AC Hotel

I have reviewed the proposed landscape & tree updates and find them acceptable.

**LANDSCAPE AND LIGHTING PLAN**

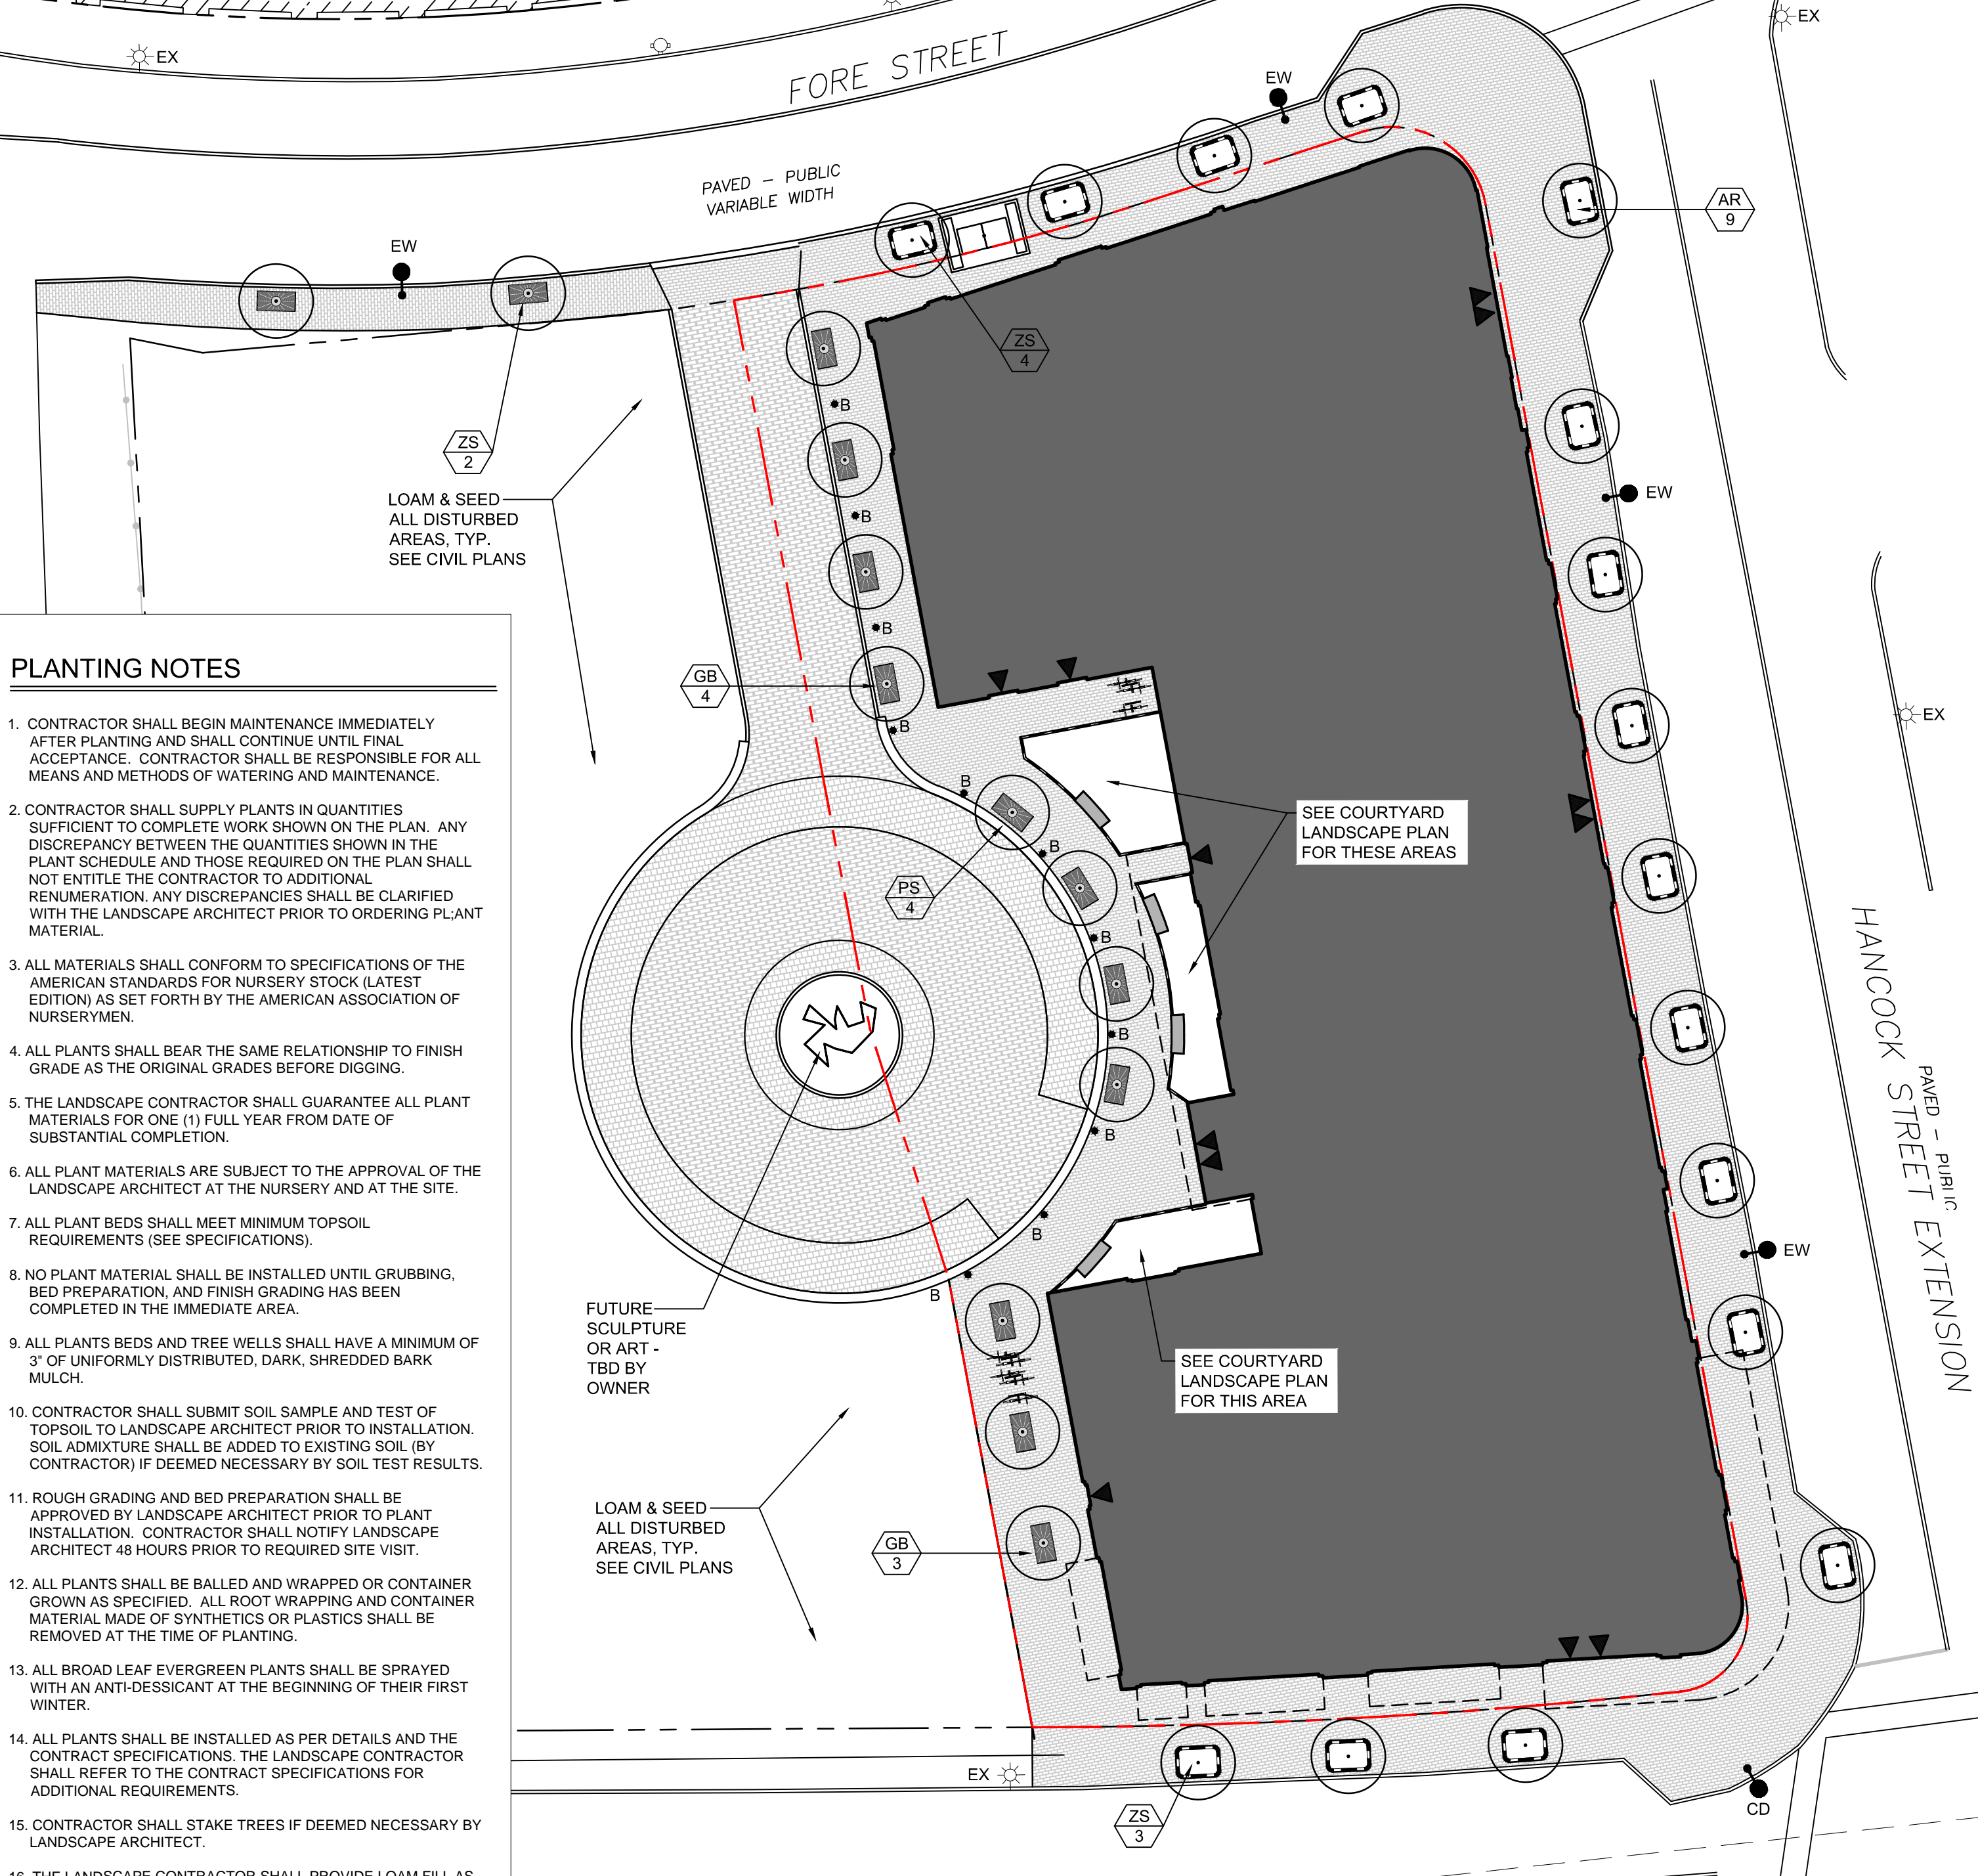
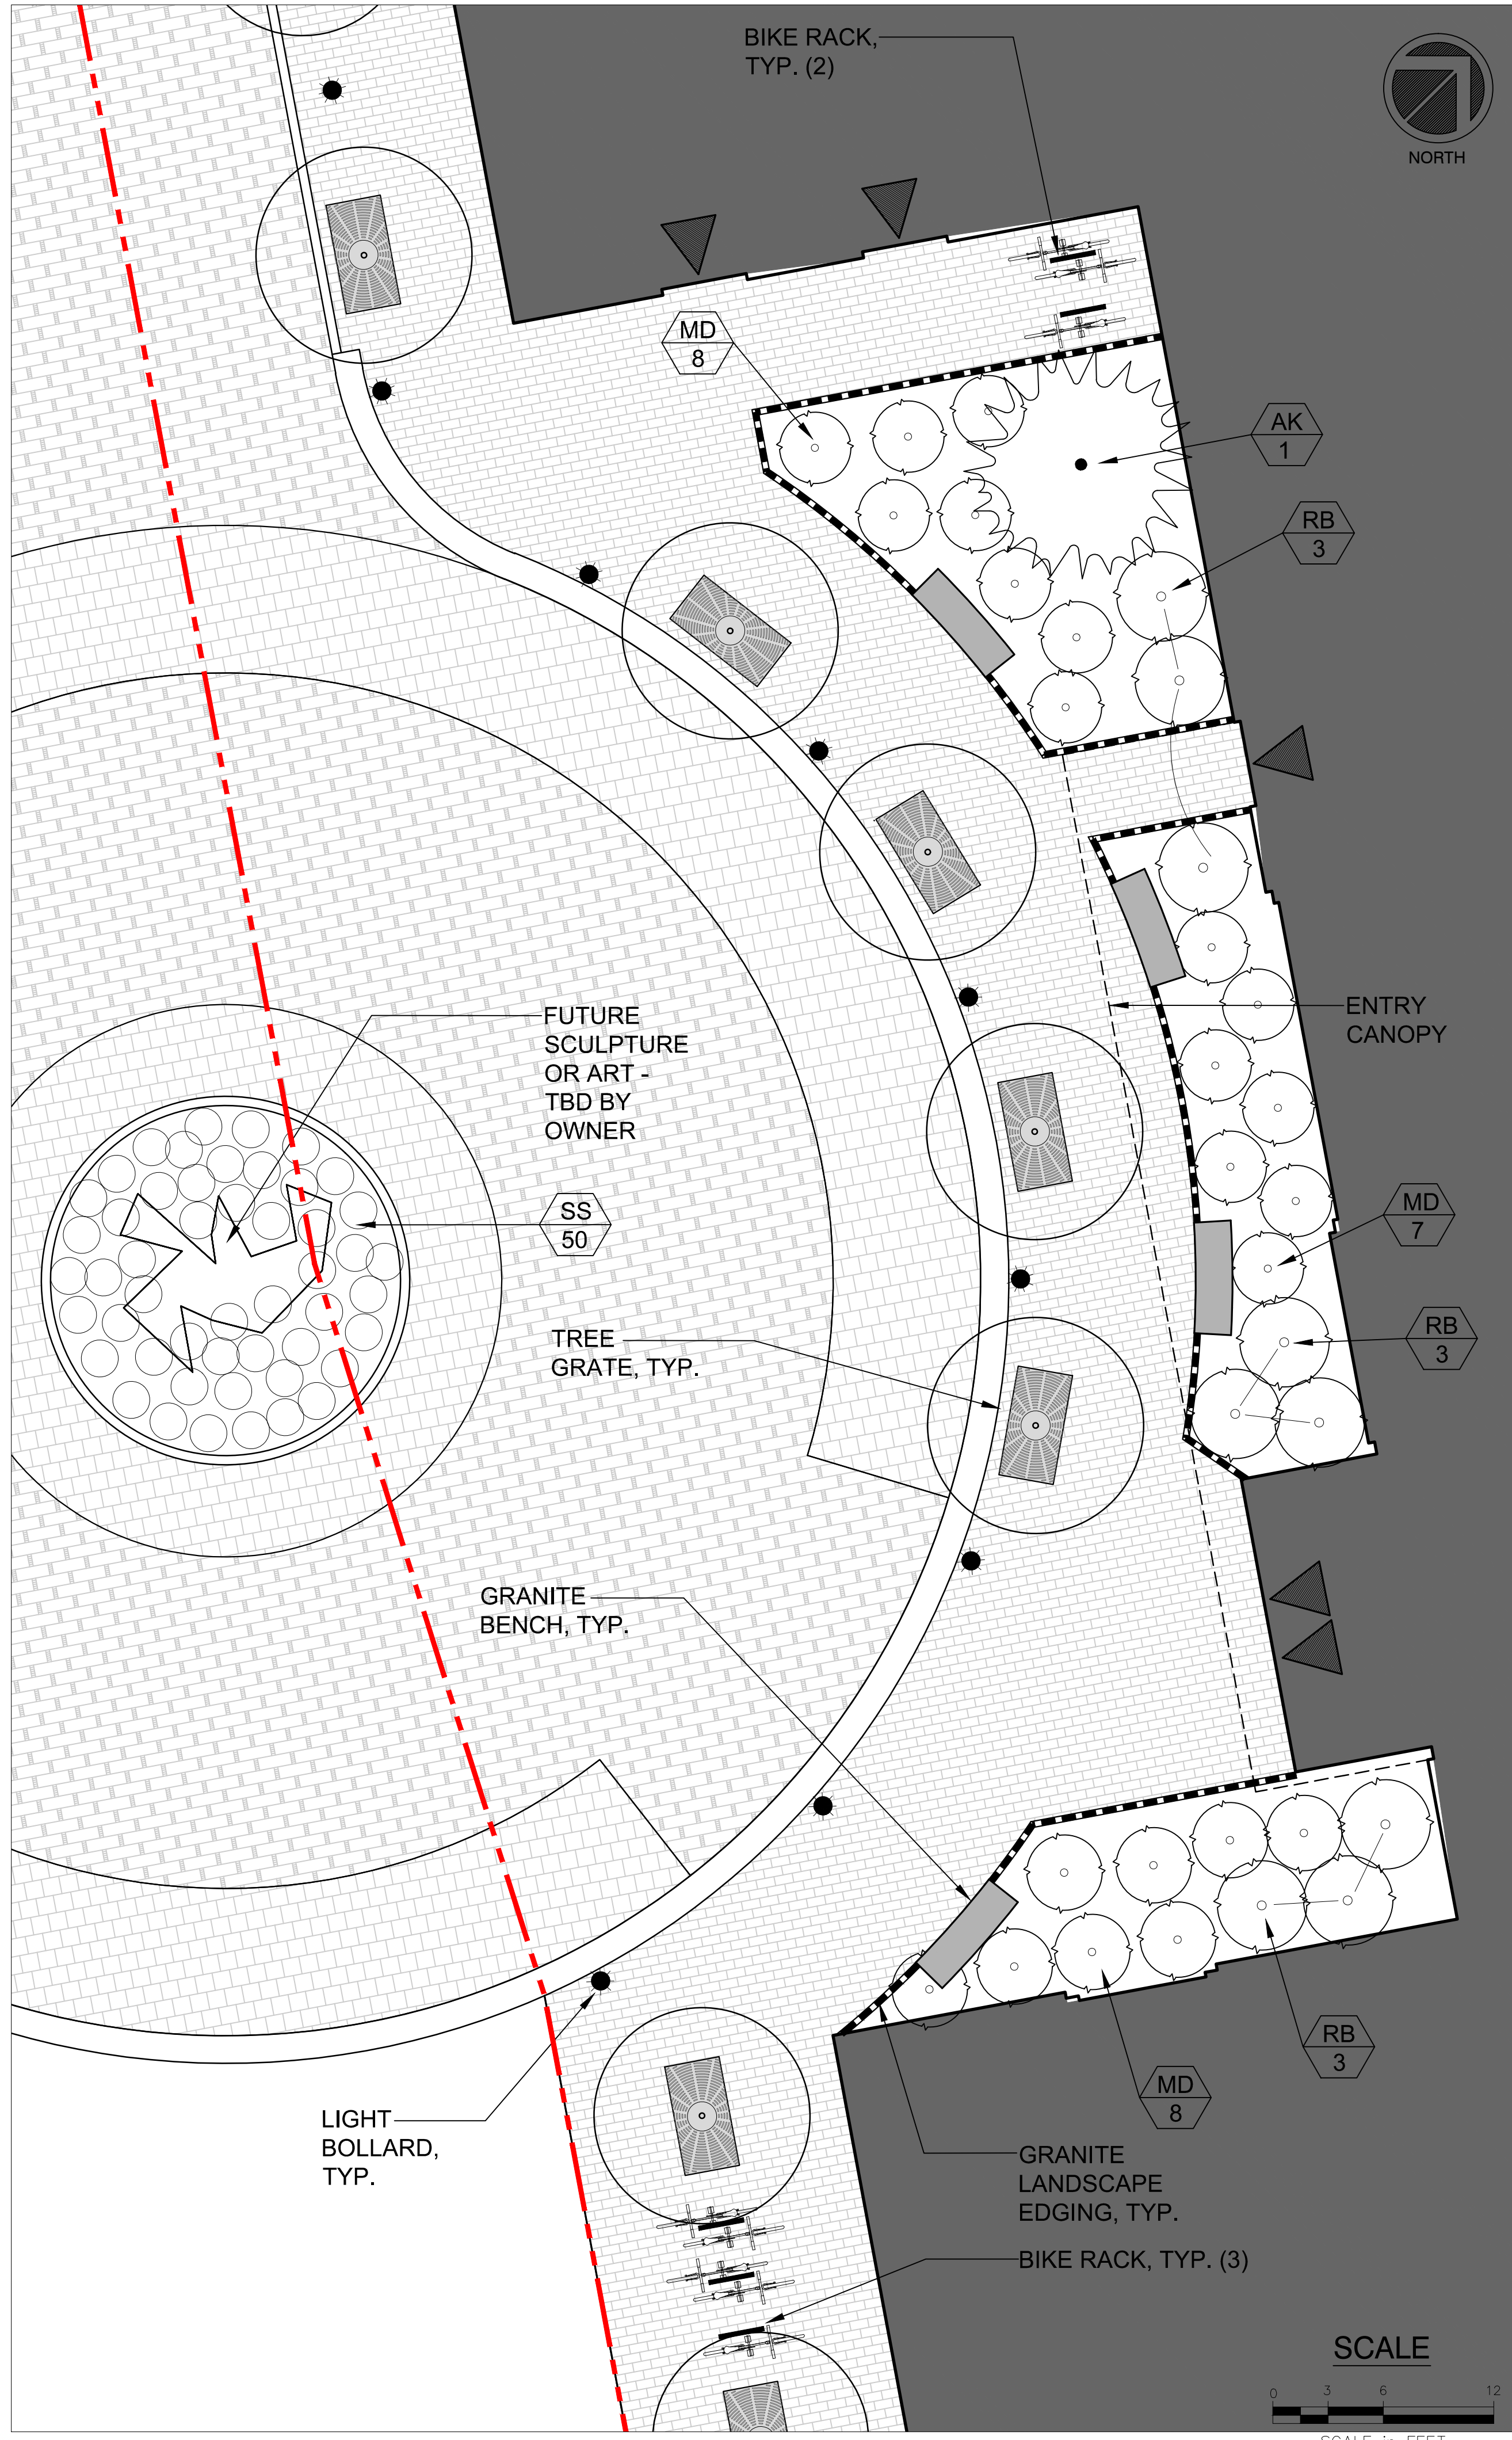
The Themes Street tree planters are now granite and adjusted to fit into the landscape. We used the trees on Commercial Street at Franklin as the example.

They have been replaced 3 times in five years due to salt...
